CLEAR VIEW INDUSTRIAL PARK, FILING 2A

GRADING, STORM AND EROSION CONTROL PLANS

Figure 13-12b. Emergency Spillway Profile at Embankment

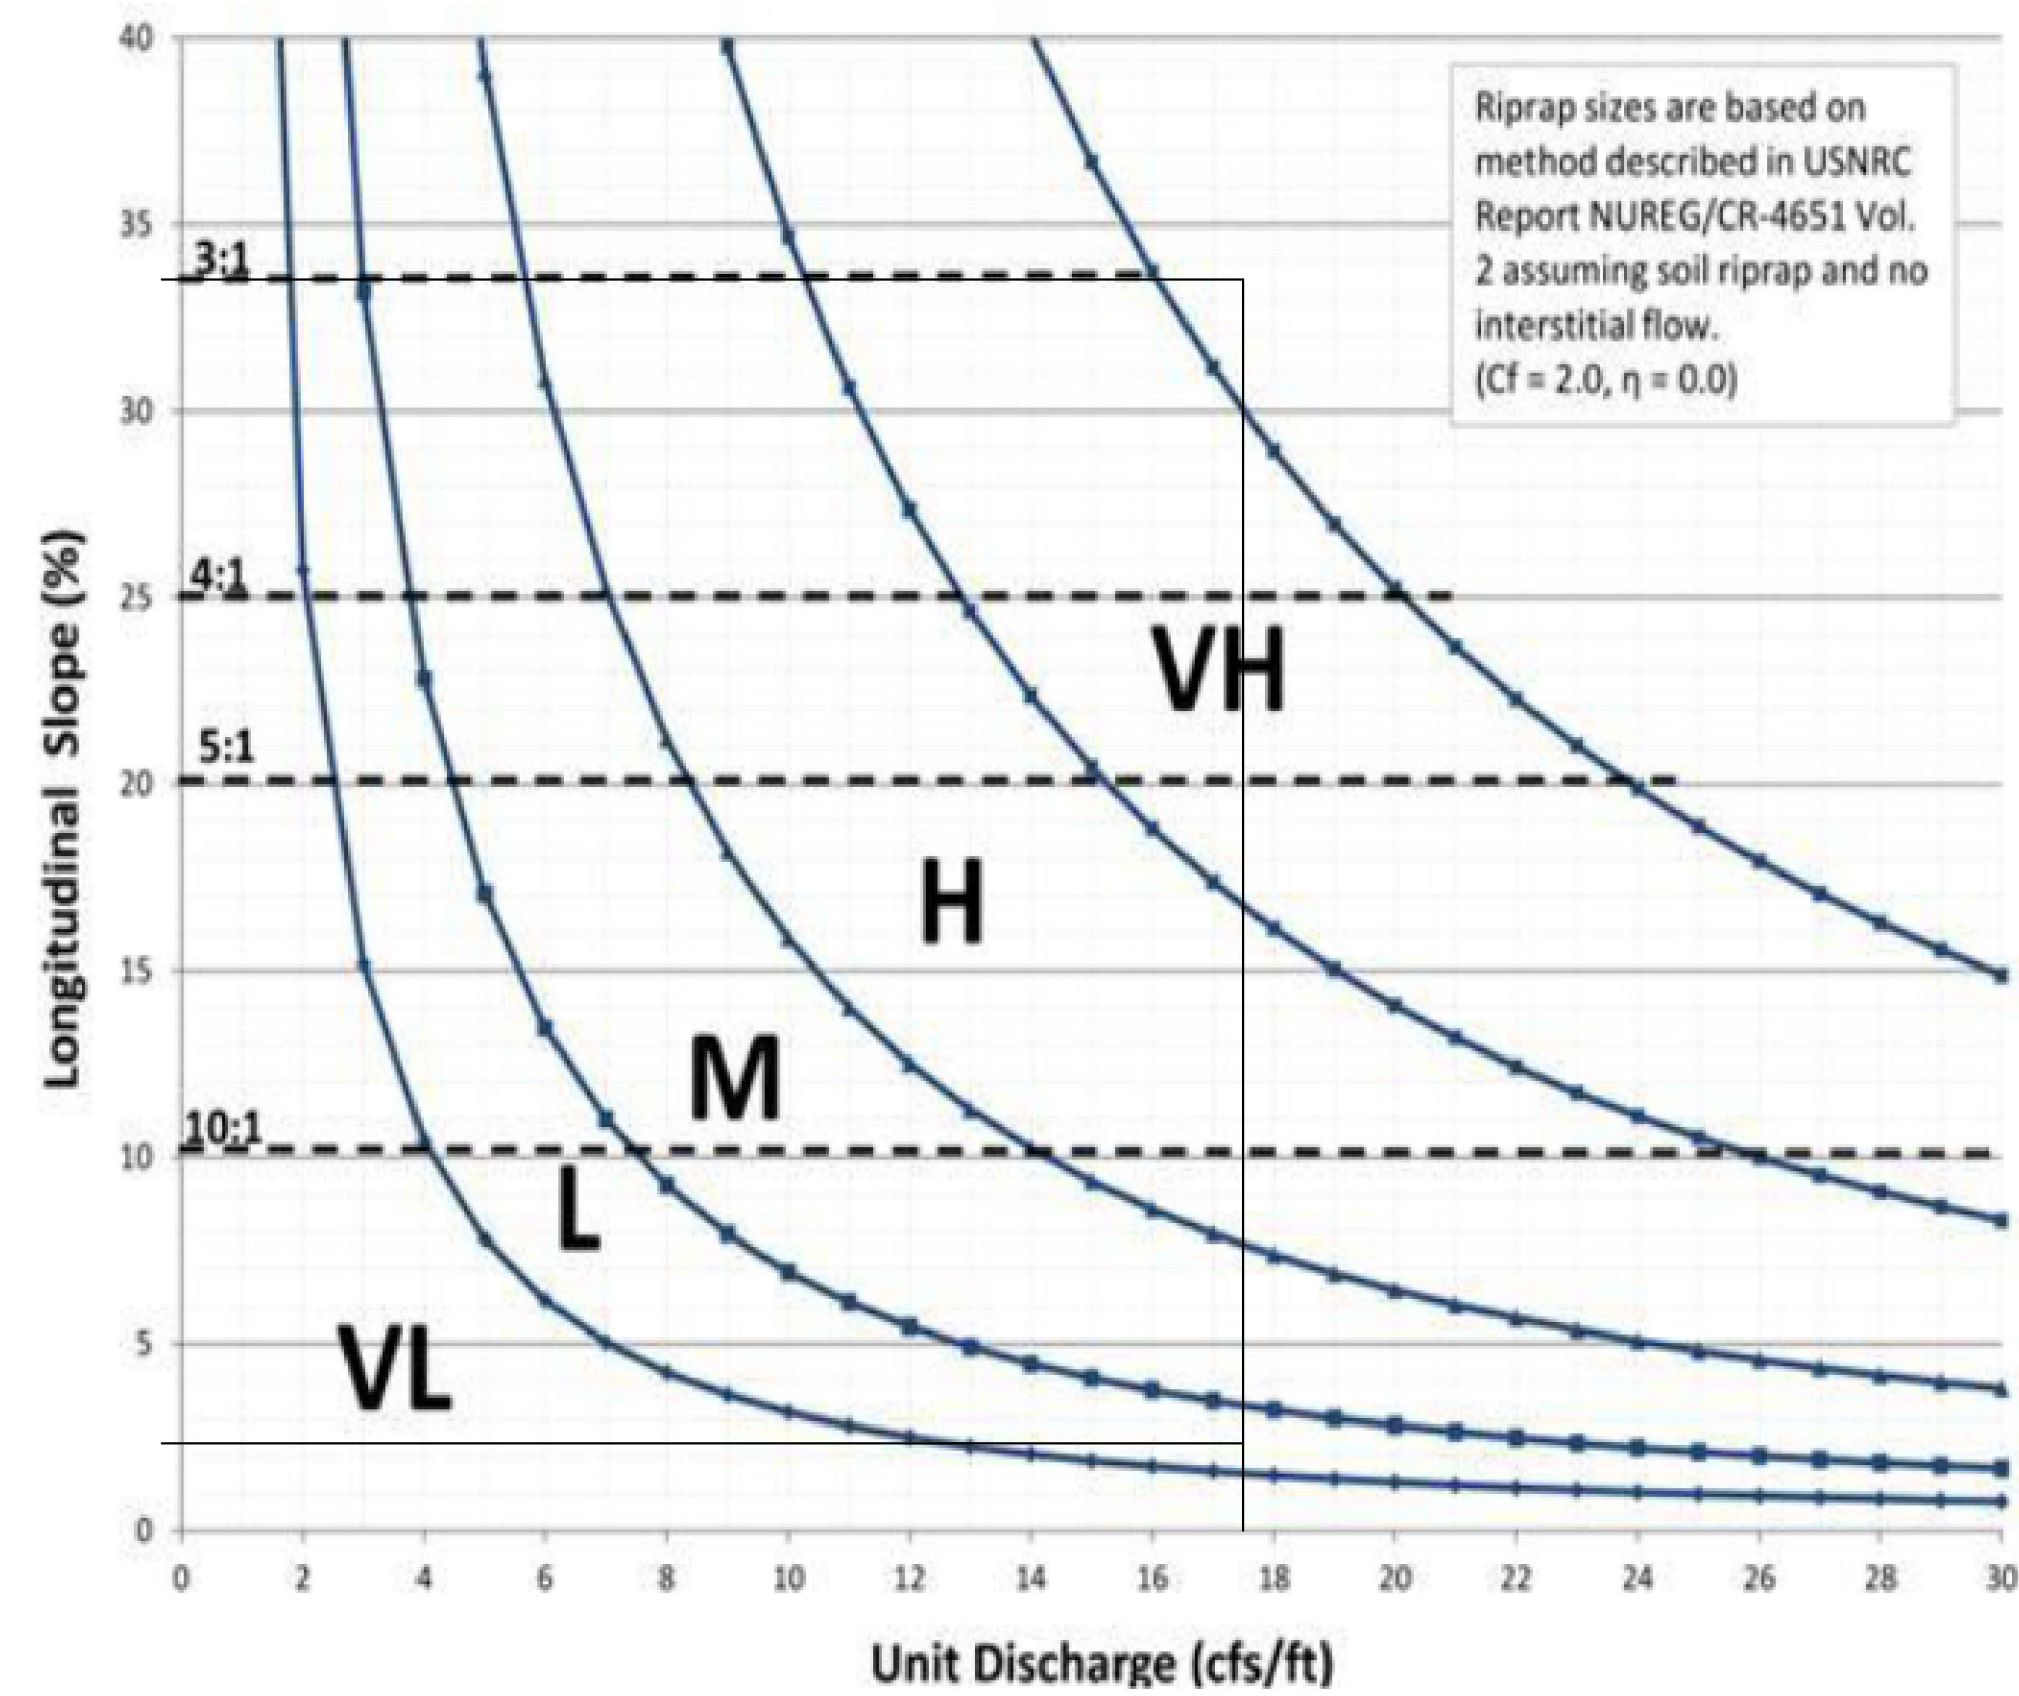
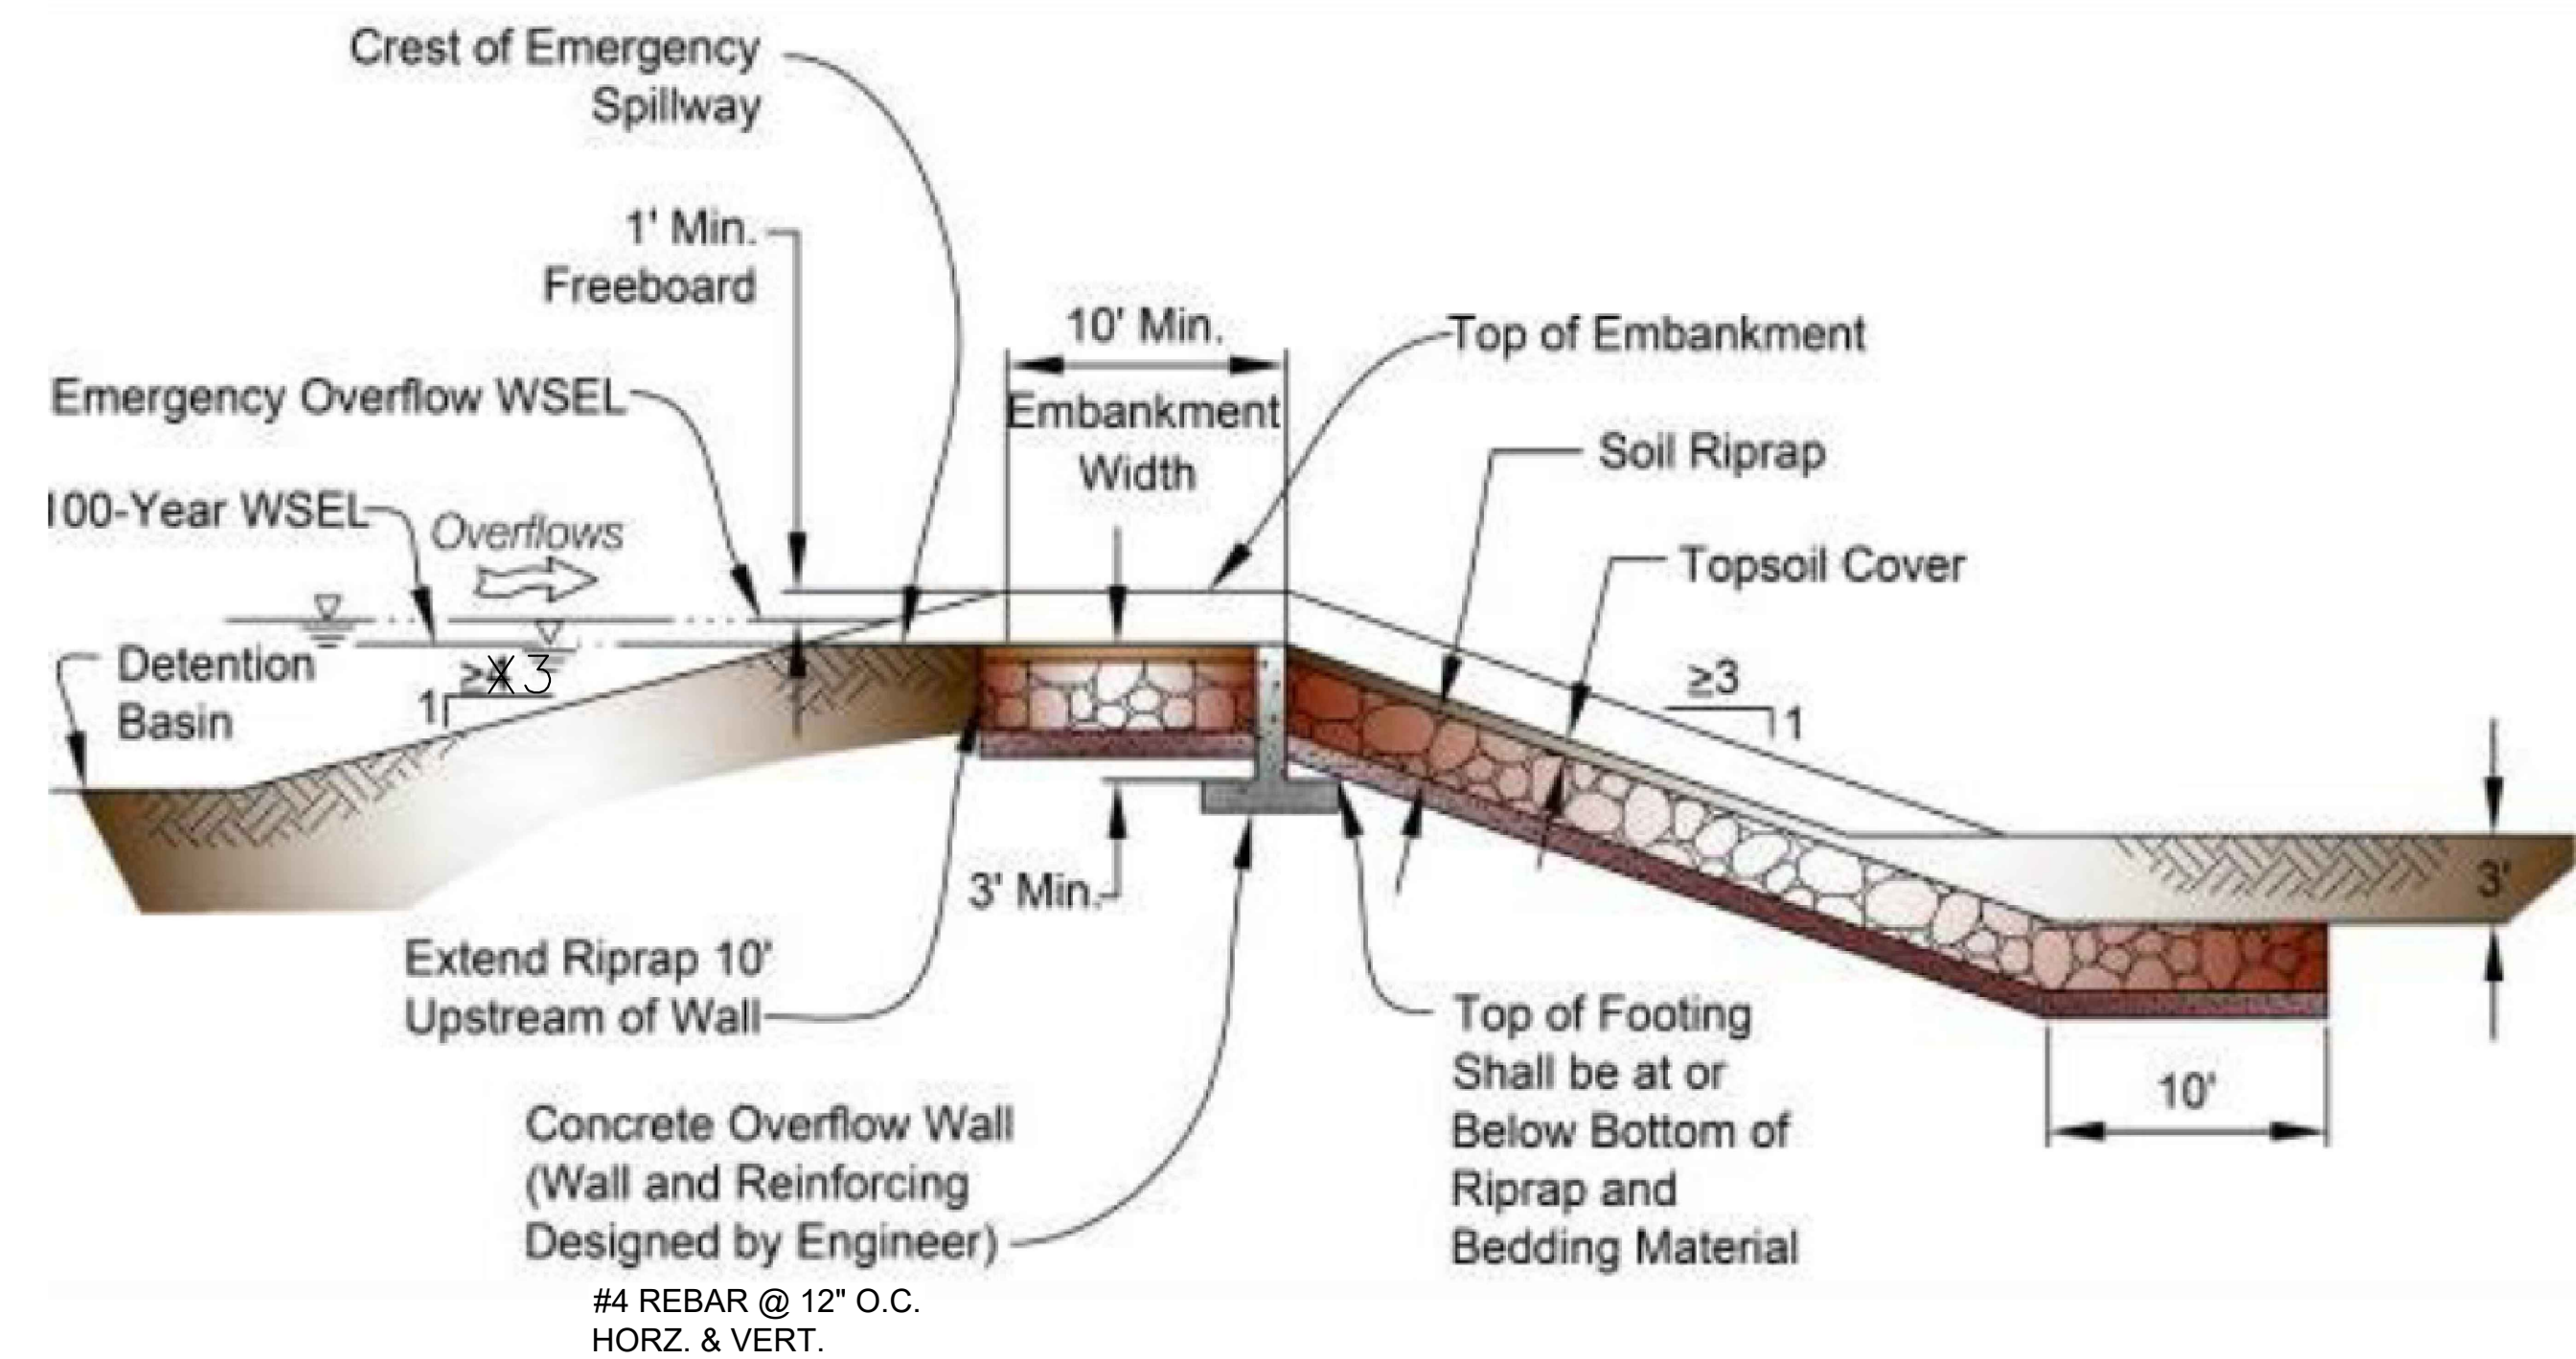
Add a section cut symbol or provide a callout on the grading plan corresponding to this spillway detail
